Director of Environment & Infrastructure:  
Mark Kemp

**RE: 6/2018/3292/MAJ – 41 Broadwater Road, Welwyn Garden City, AL7 3AX**

We understand this application seeks full planning permission for a major development, and we have assessed the Proposed Surface Water Drainage Strategy prepared by NJP Consulting Civil & Consulting Engineers Ltd, reference RN/10528, version 1.00, dated June 2019 and additional information submitted to support to this application. However, the information provided to date does not provide a suitable basis for an assessment to be made of the flood risks arising from the proposed development.

Julia Puton  
SuDS Officer  
Hertfordshire County Council

# BRE365 SOIL INFILTRATION RATE TEST - TP4

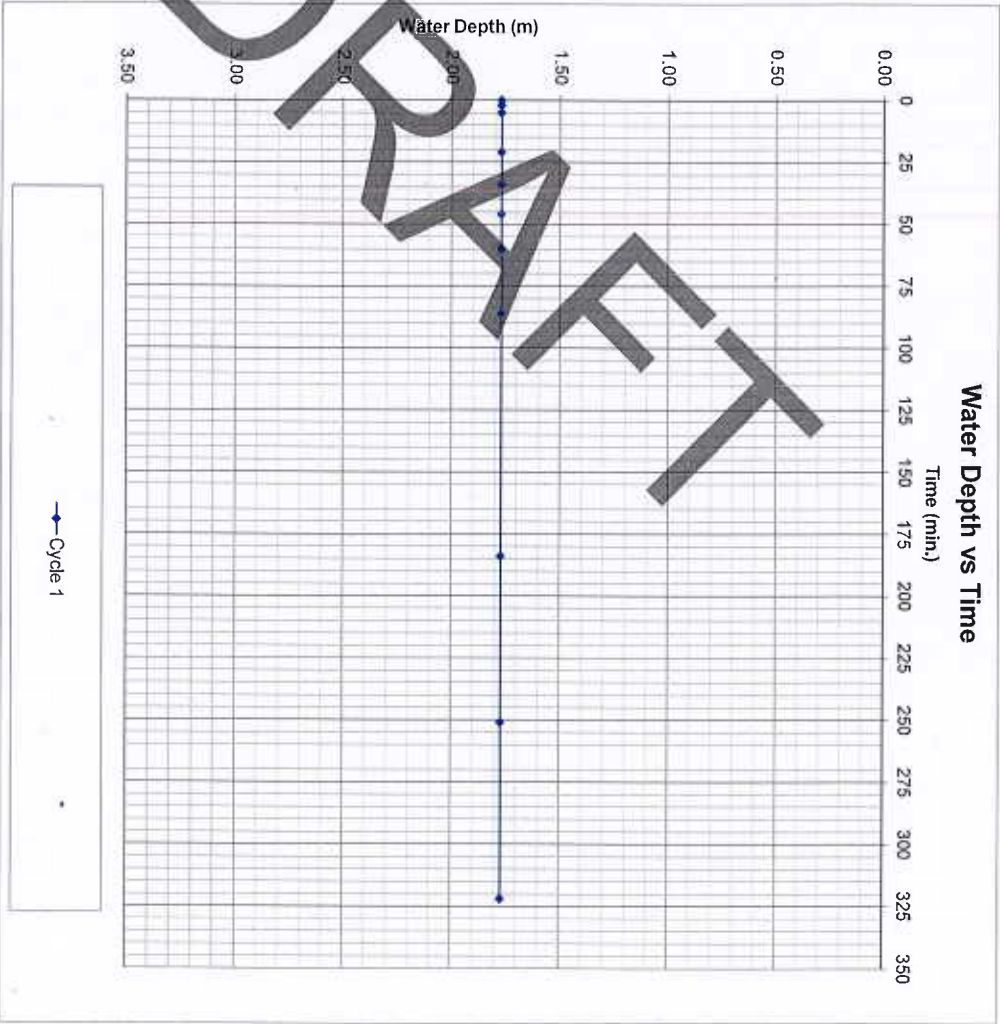
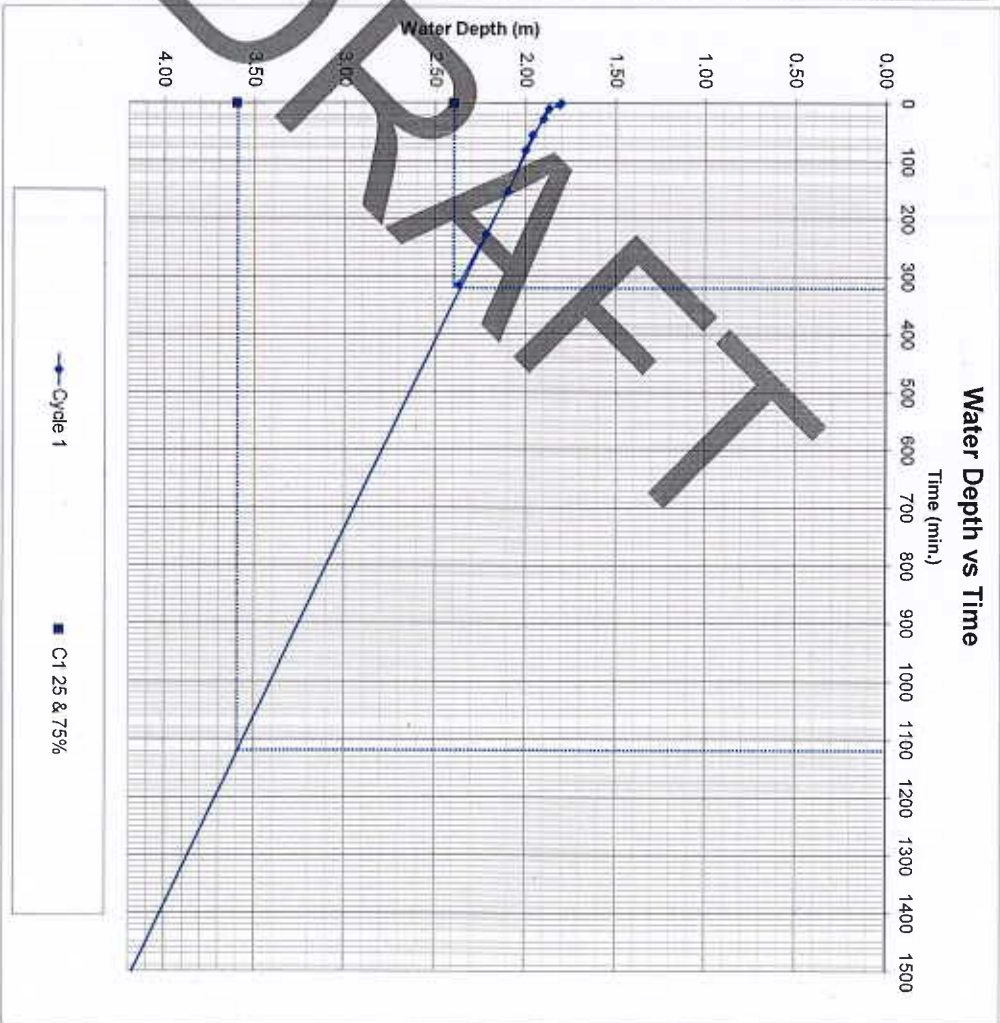
Based on the provided infiltration test results, as the LLFA we would base the modelling on the worst obtained infiltration results. Therefore, we would consider that infiltration is not viable on the site.

We note that groundwater has been identified at 1.5 m below ground levels. This should be clarified by the applicant, as we understand that infiltration is being proposed between 3 to 4 metres below ground level.

**TYPICAL SECTION THROUGH BLOCK PAVED PARKING BAY AND PERMEABLE DRAINAGE**

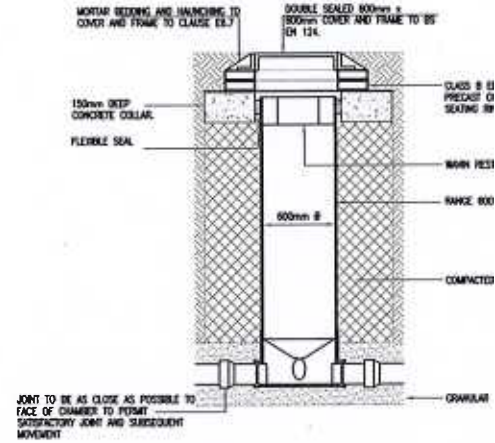
We note that the submitted modelling includes permeable paving feature with direct infiltration into the ground. As stated in the report, shallow infiltration does not work on the site and therefore deep bores are being considered. Therefore, we would advise the applicant that appropriate modelling should be submitted.

**HYDRO BRAKE CHAMBER PLAN**

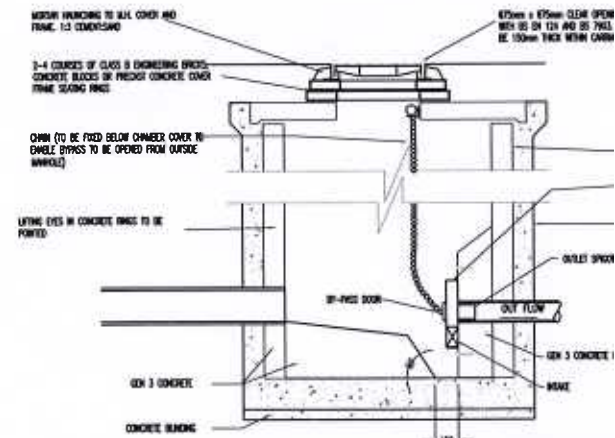
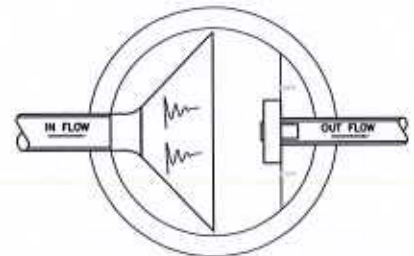
We note that a hydrobrake feature is being proposed to limit surface water discharge from permeable paving area. However, we note as well that additional connection from the access road has been included on the drainage layout. Therefore, our understanding is that the final discharge from the site exceeds 2 l/s. We would advise that the applicant should clarify this.
